Rezoning Transportation Analysis

Petition Number: 2022-210

General Location Identifier: 14506122, 14506121, 14506128, 14506120, 14606126

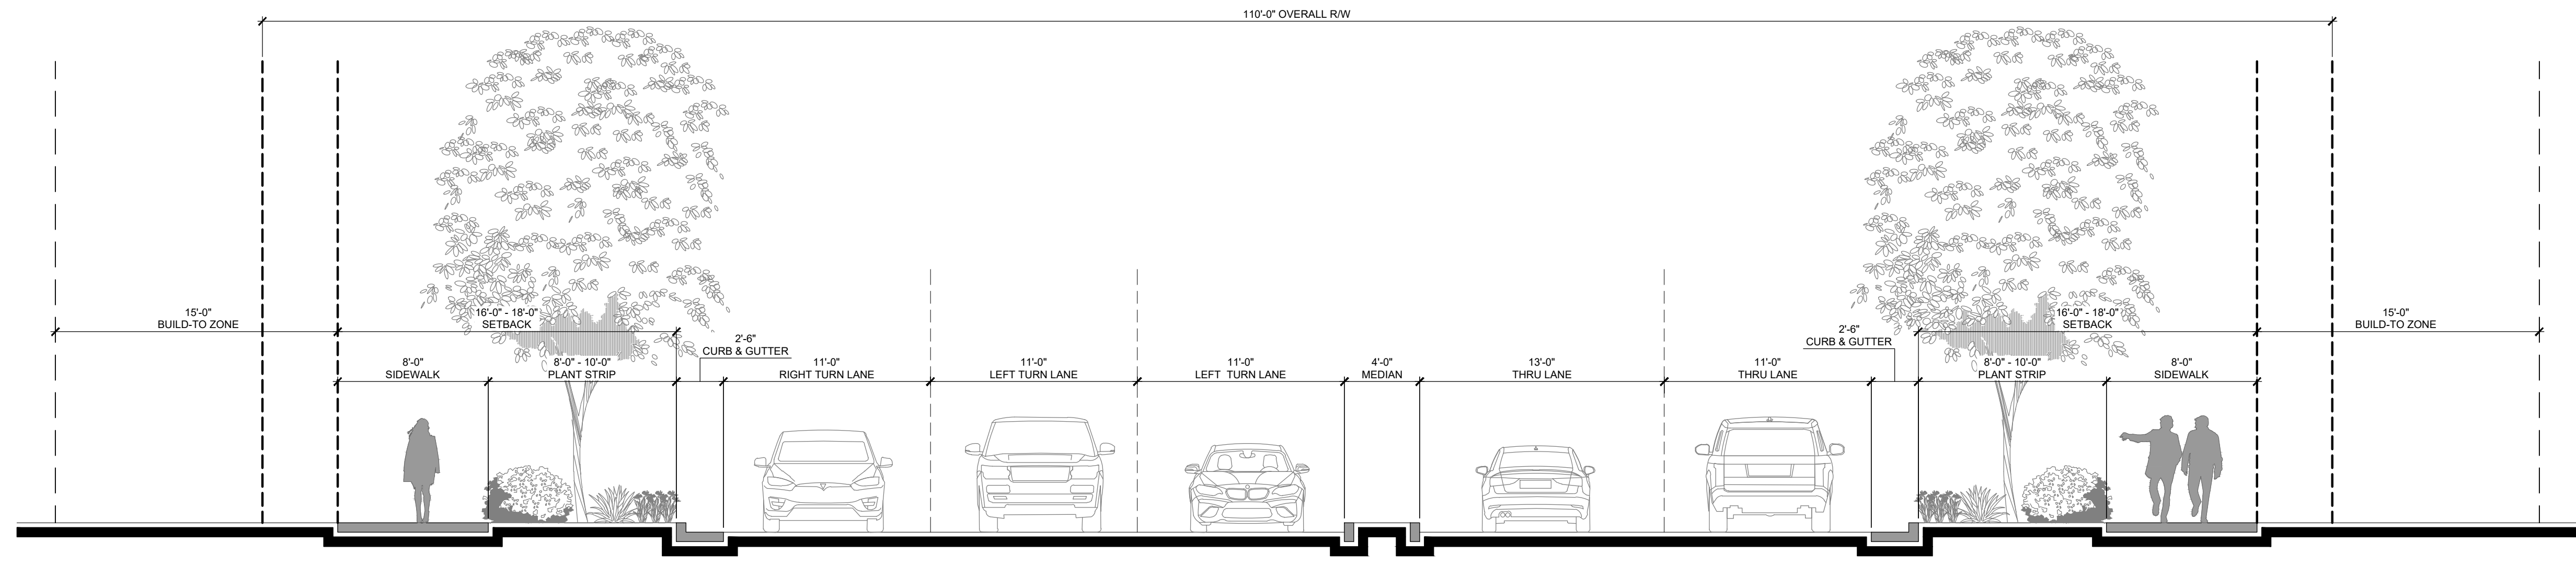
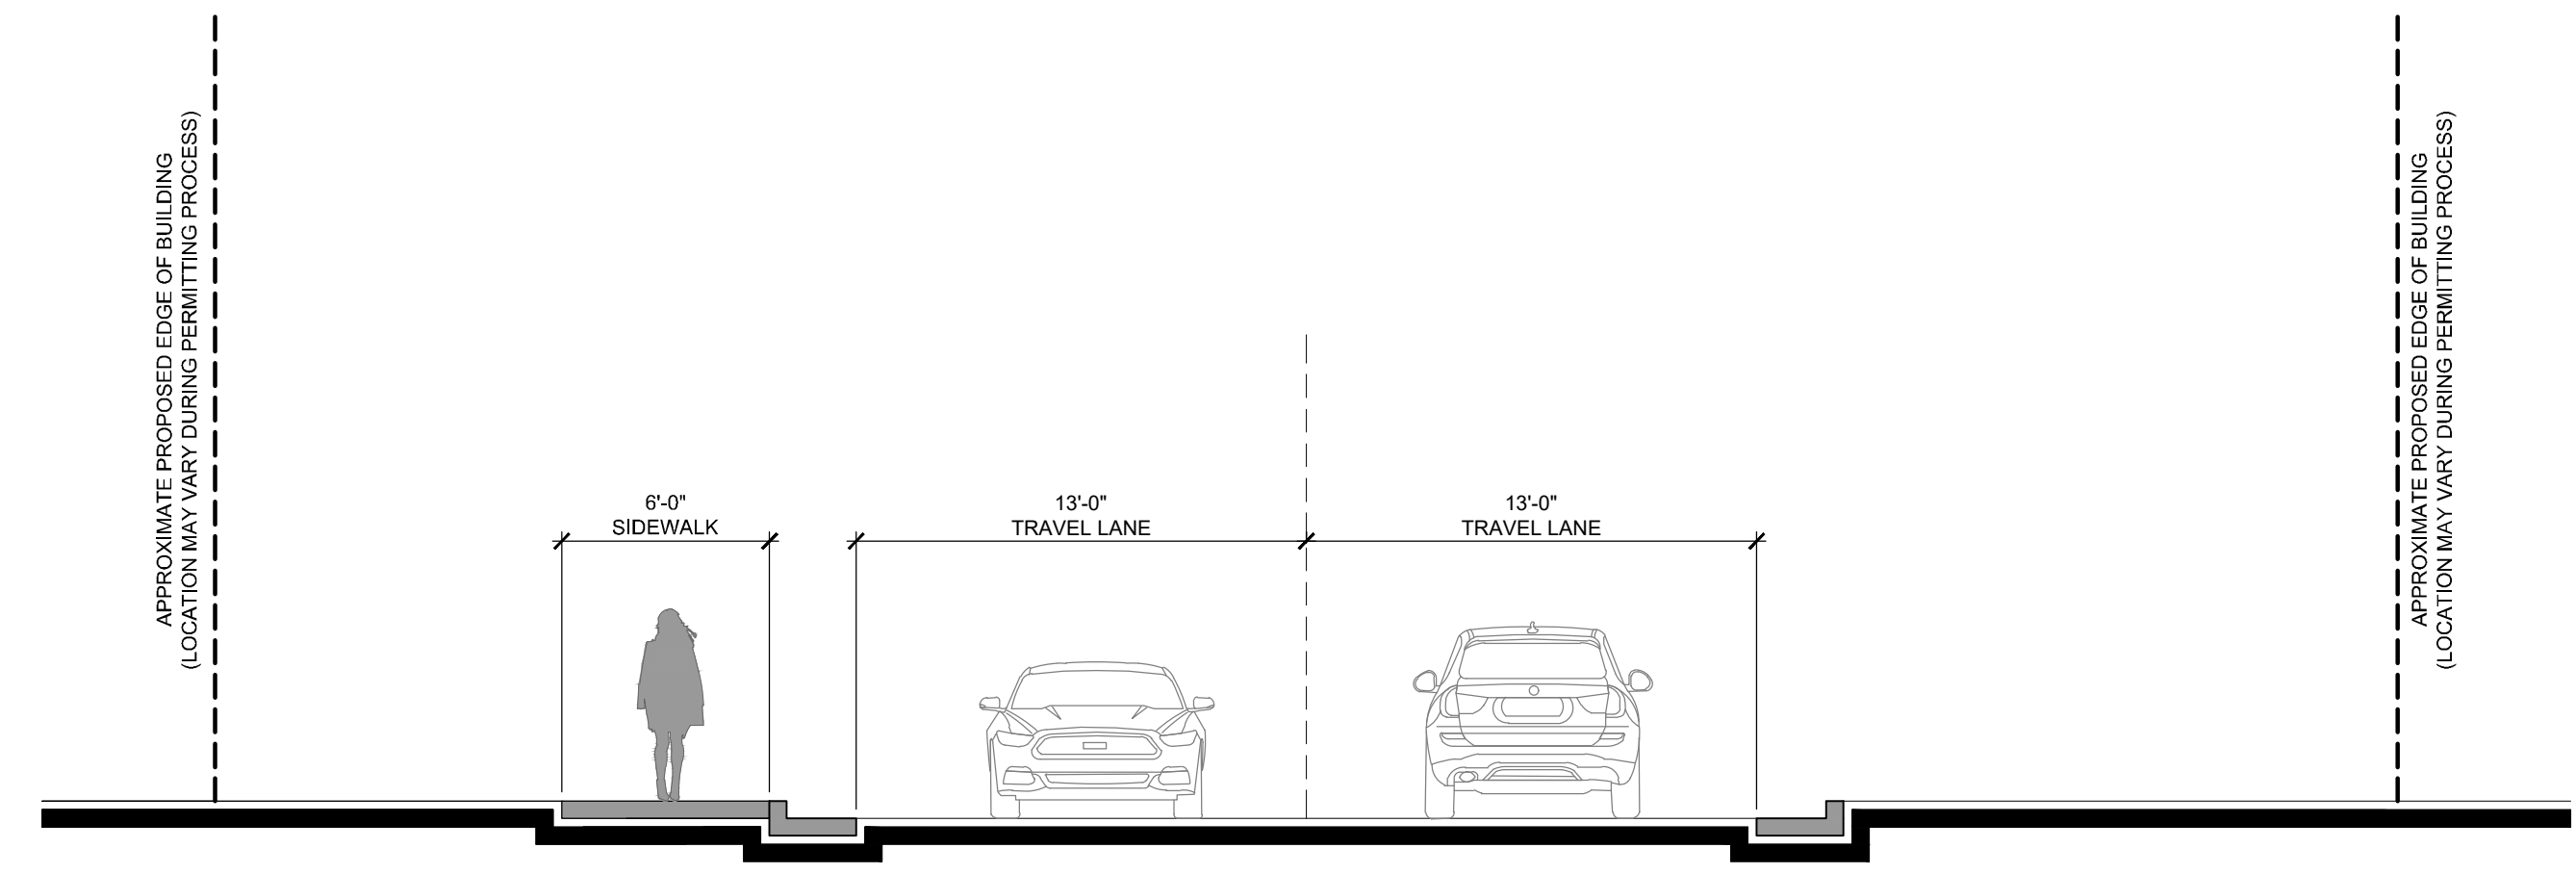
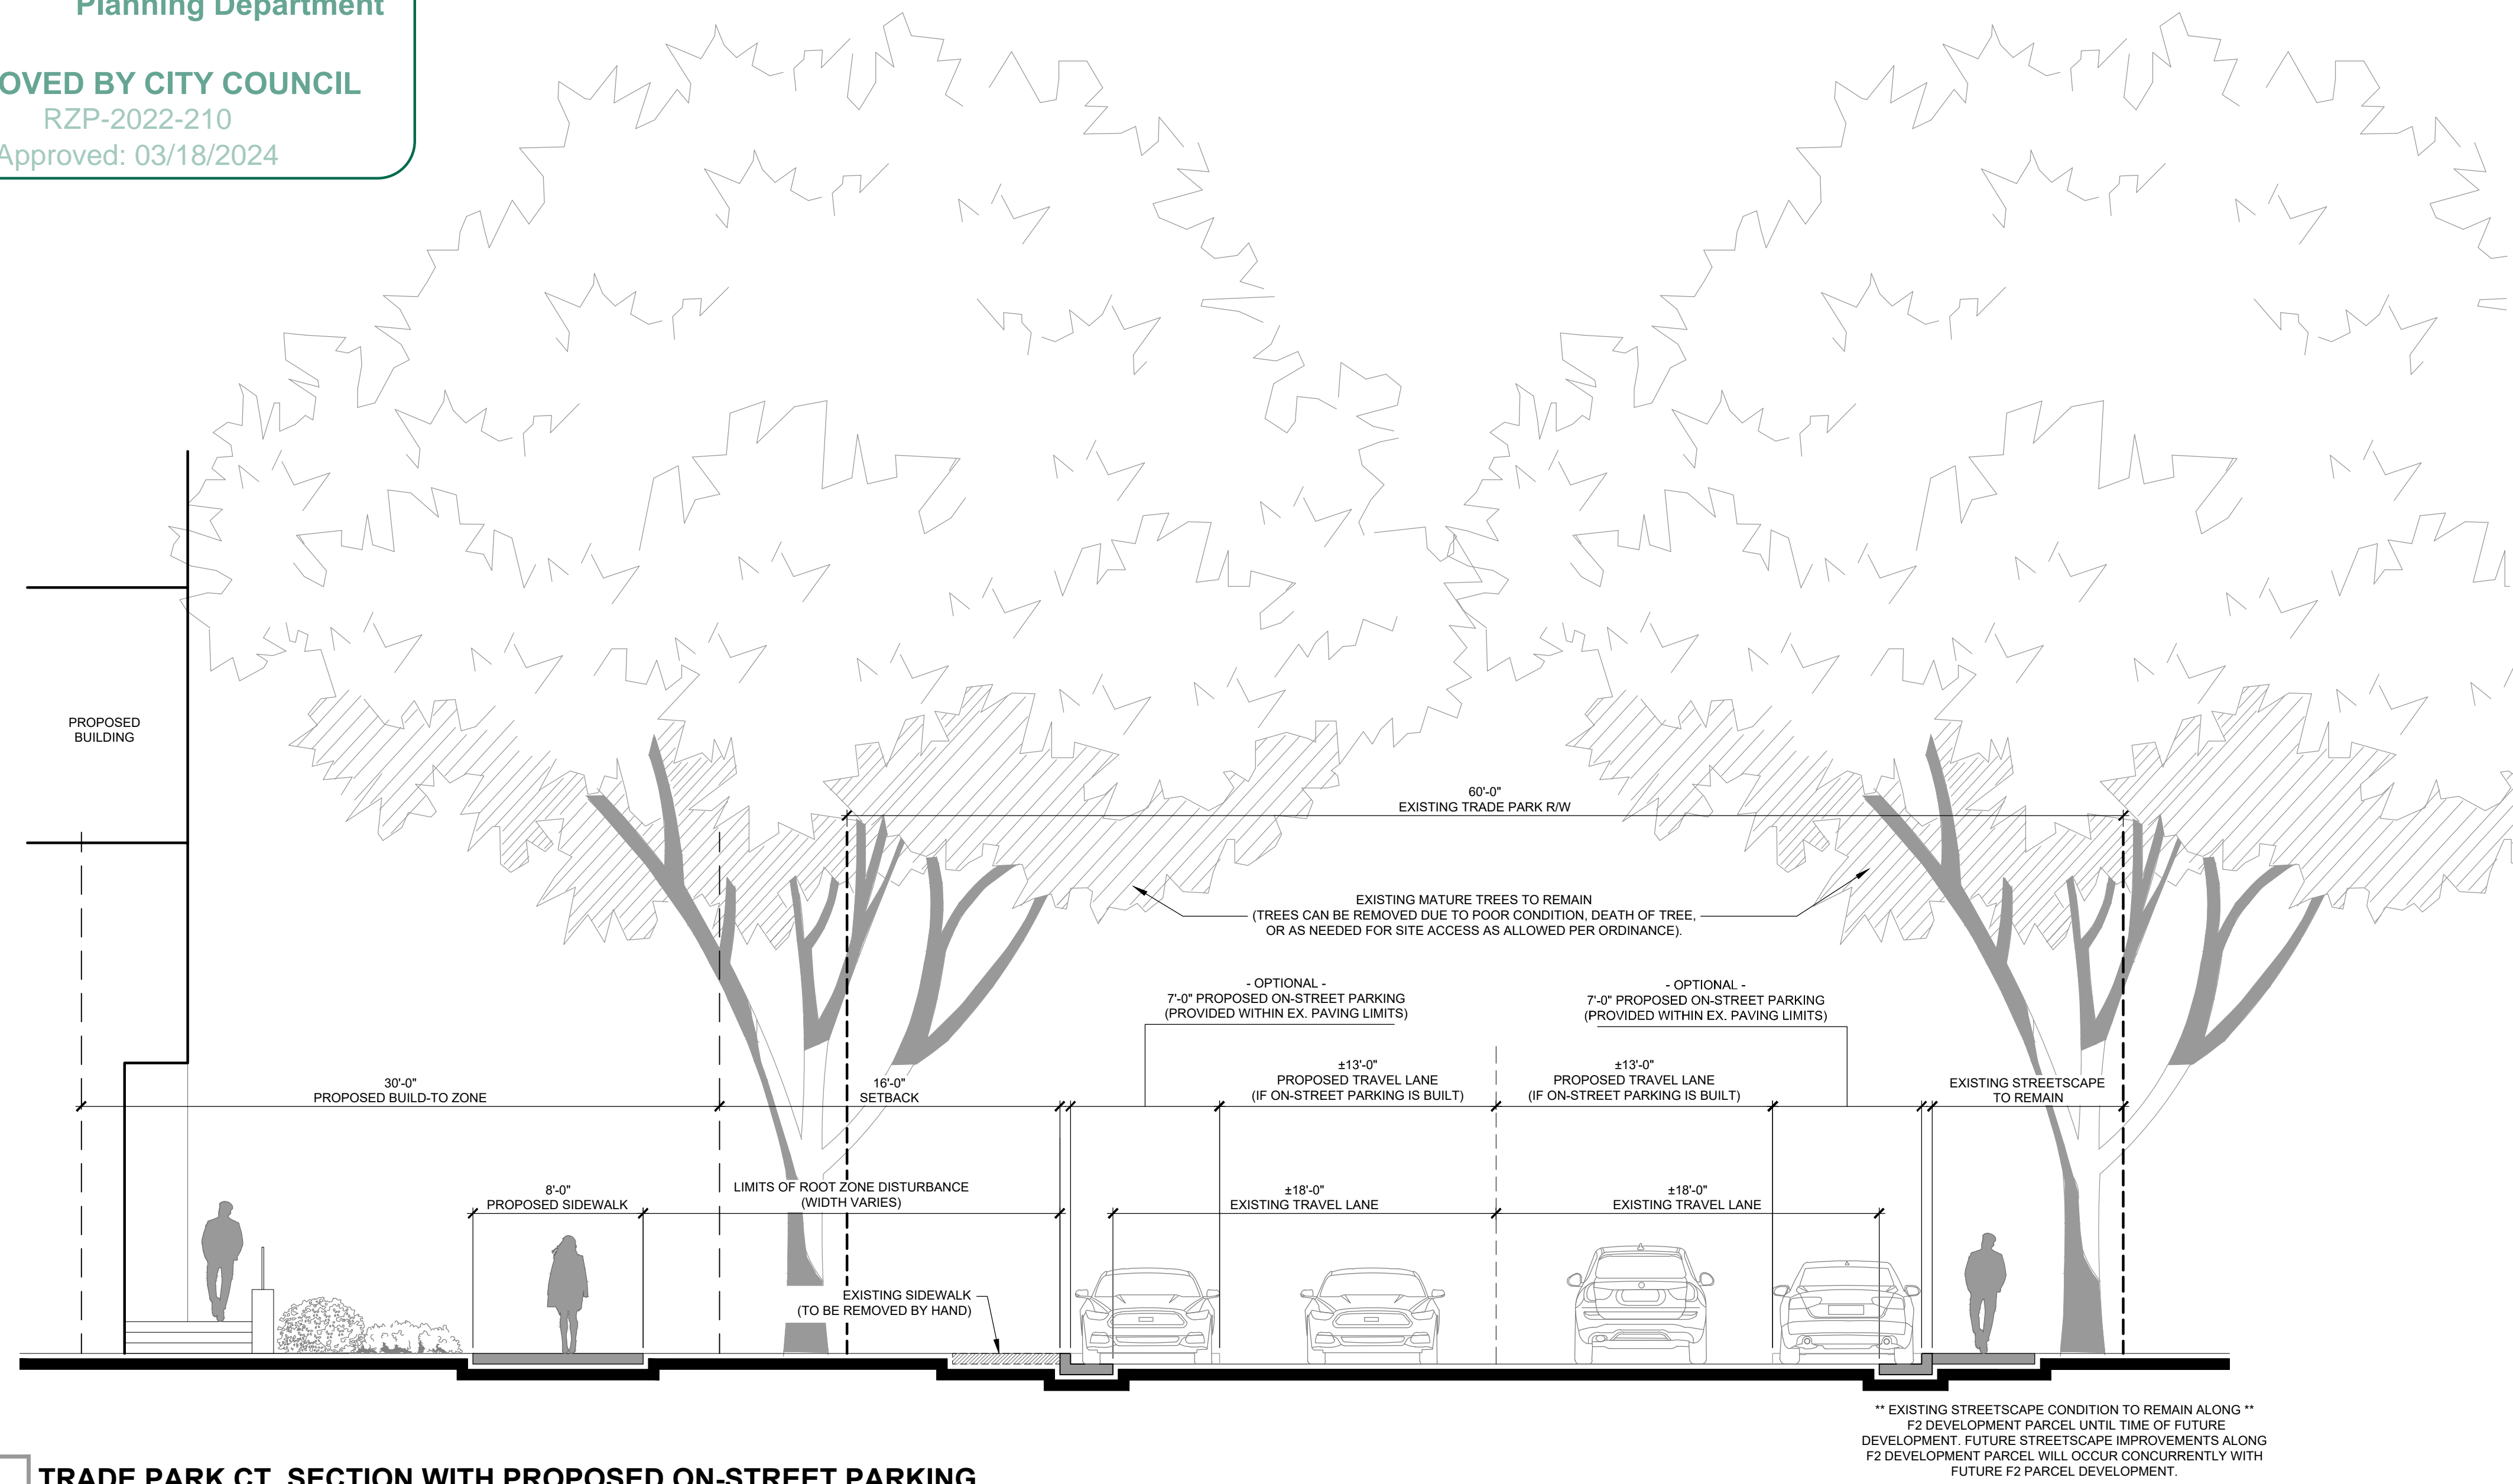
~~**Outstanding Comment 9.20.23:** Revise internal street network to standard public street typical sections per the CLDSM or provide additional information on existing constraints for review and approval of nonstandard typical sections.~~

Provide additional info on why modifications are necessary

f. To allow modifications to the required public and network required street cross sections as generally depicted on Sheet RZ.01.
